From: Sue Howell [REDACTED]
Sent: 30 November 2021 11:38
To: Michael Eastham <[REDACTED]>
Subject: Landscape consultation response re CM/48/21/RES

To clarify my consultation response re CM/48/21/RES.

Revision N
Project Land at Climping Littlehampton
Title Site Plan
Dwg# 20.050.02
Status Planning

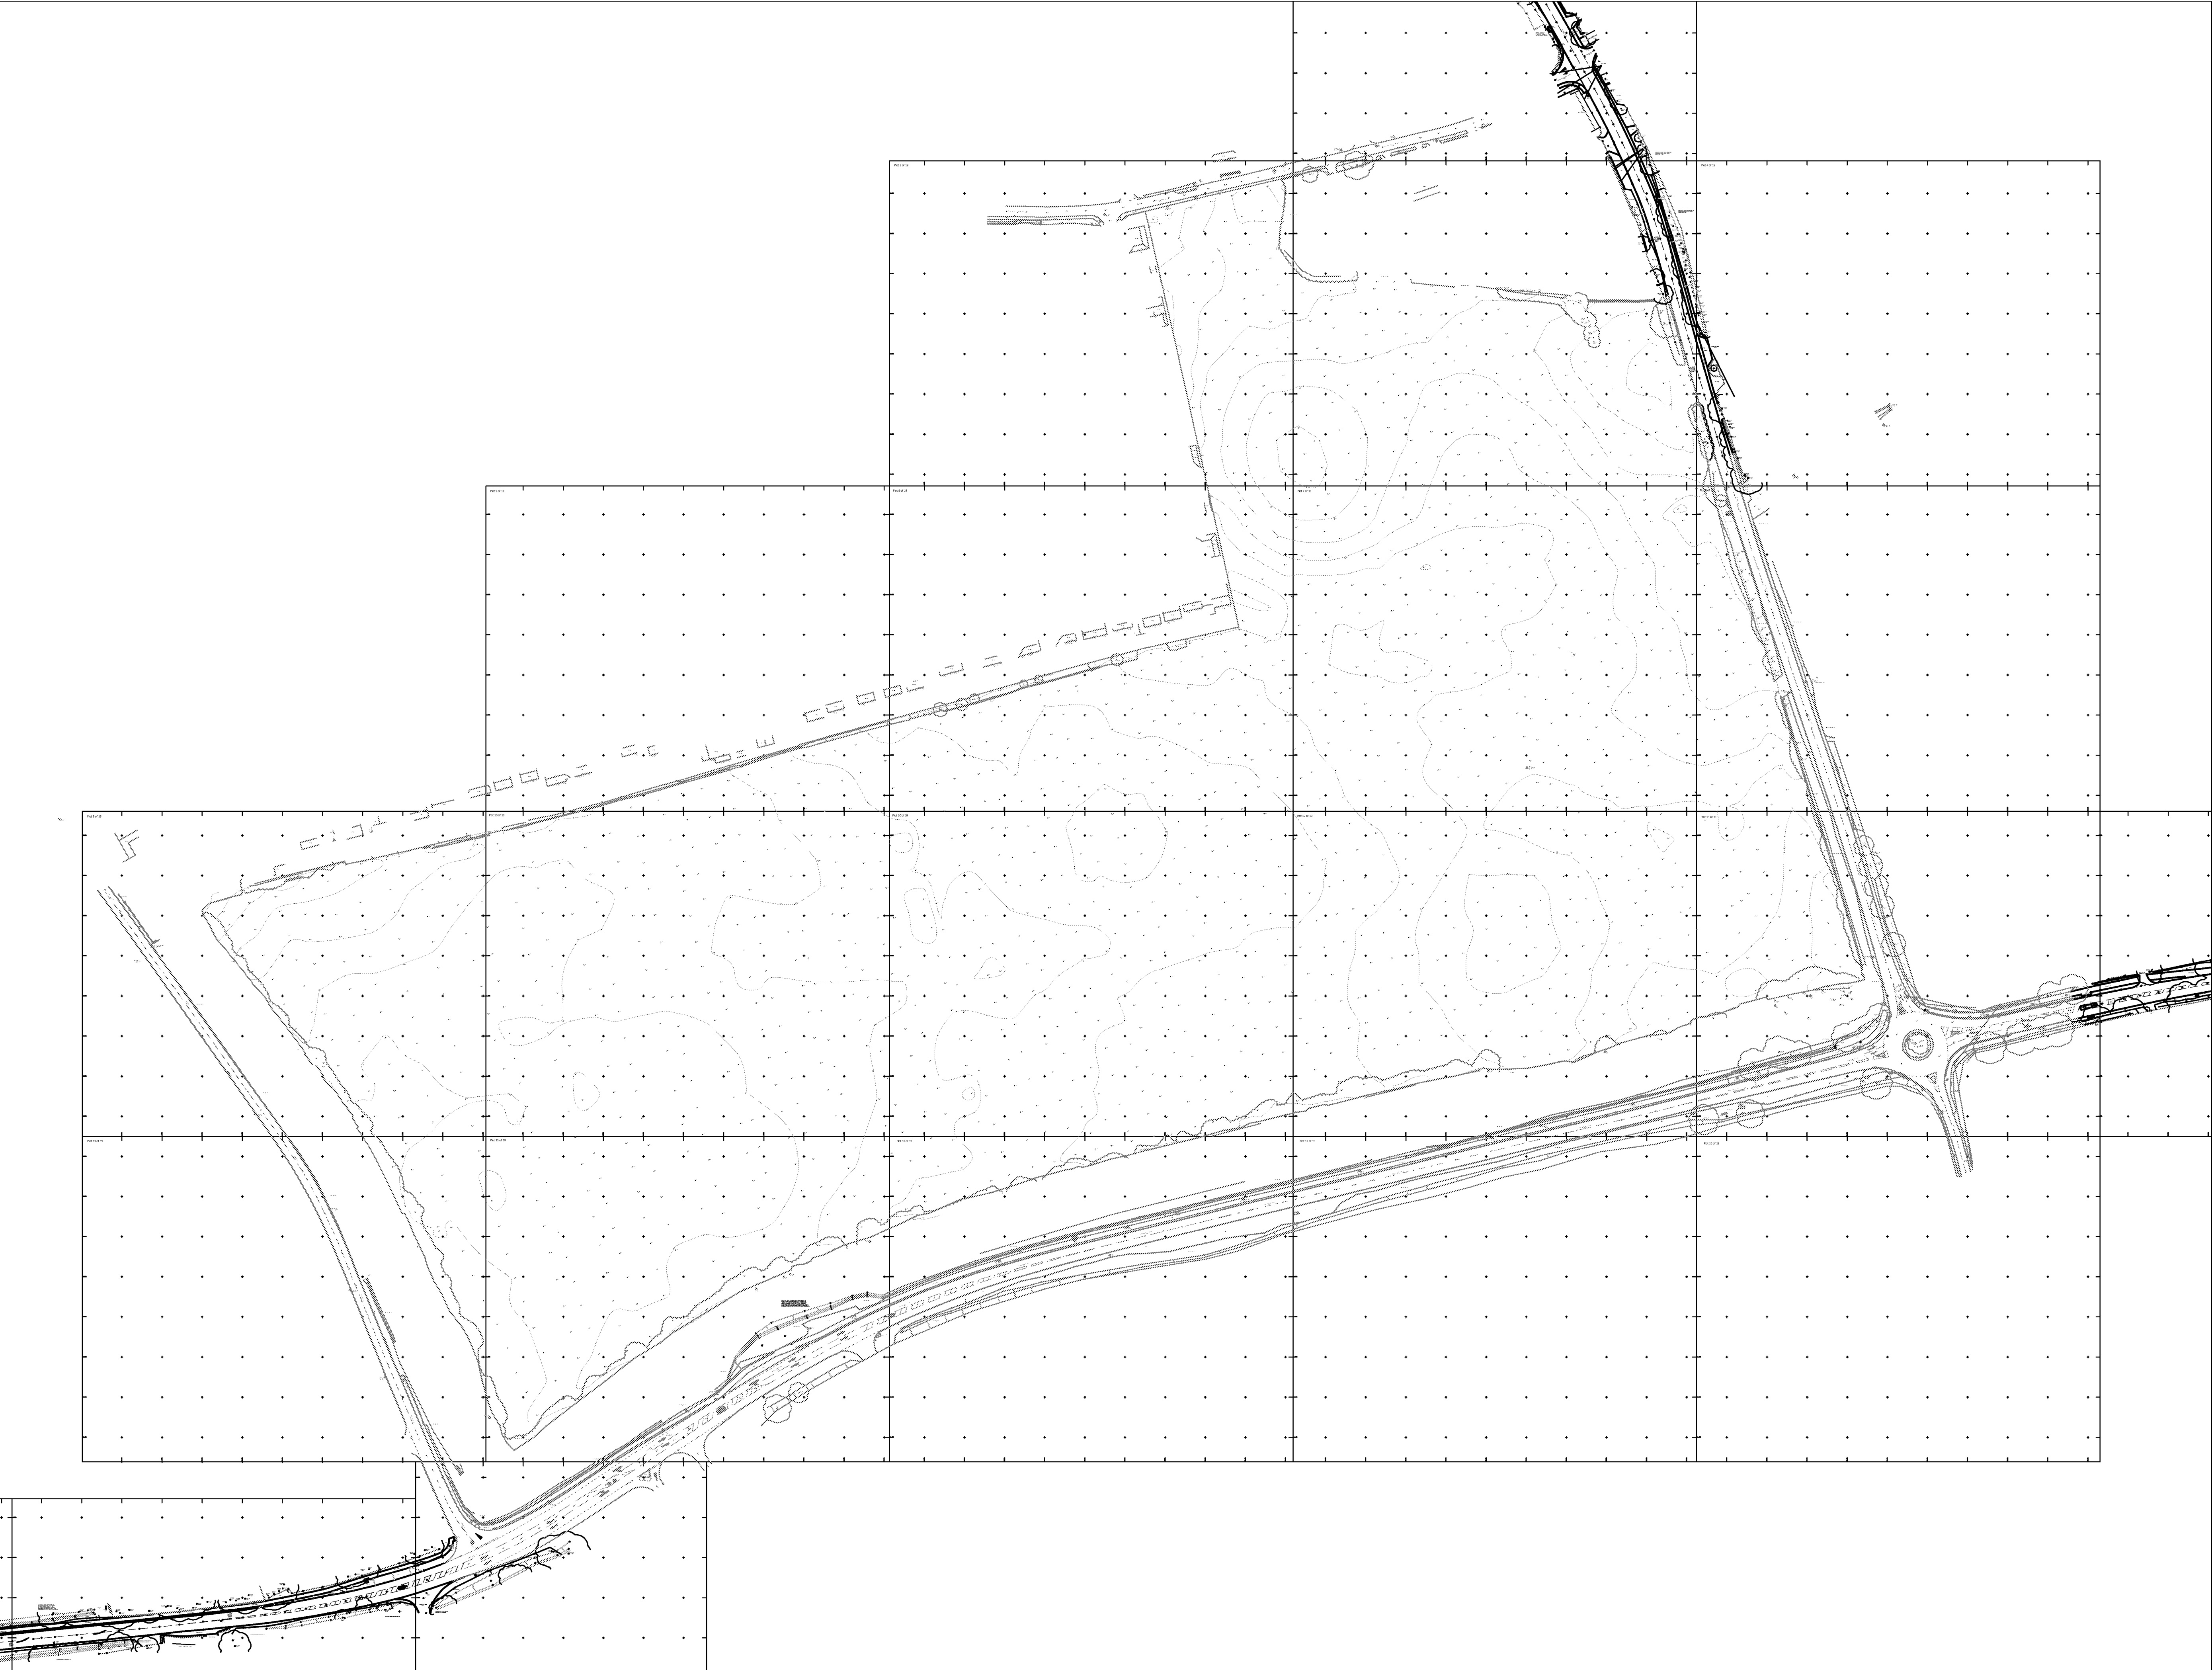
I would however still recommend an objection as follows: The green infrastructure appears to have been considered in the layout proposals and improvements shown in relation to the proposal for a north south green corridor within the eastern section of the site, however this could be seen as being at the expense of the green buffer area particularly on the eastern edge, which has been depleted from the masterplan and which now appears to house significant SuDS features.

The central village green area is small in relation to the POS at the western end of the development, an increased central area would assist in the formation of sense of place and would provide a softer feel to the centre of the development.

The commercial building now appears to be surrounded by significant areas of SuDS and potentially water holding bodies.

The Masterplan appeared to give greater space between the development and to existing dwellings to the north, again a swale or SuDS feature appears in this location. It would be recommended that a good green buffer is incorporated in this location to give separation and some screening to allow privacy to the existing and new dwellings in this location
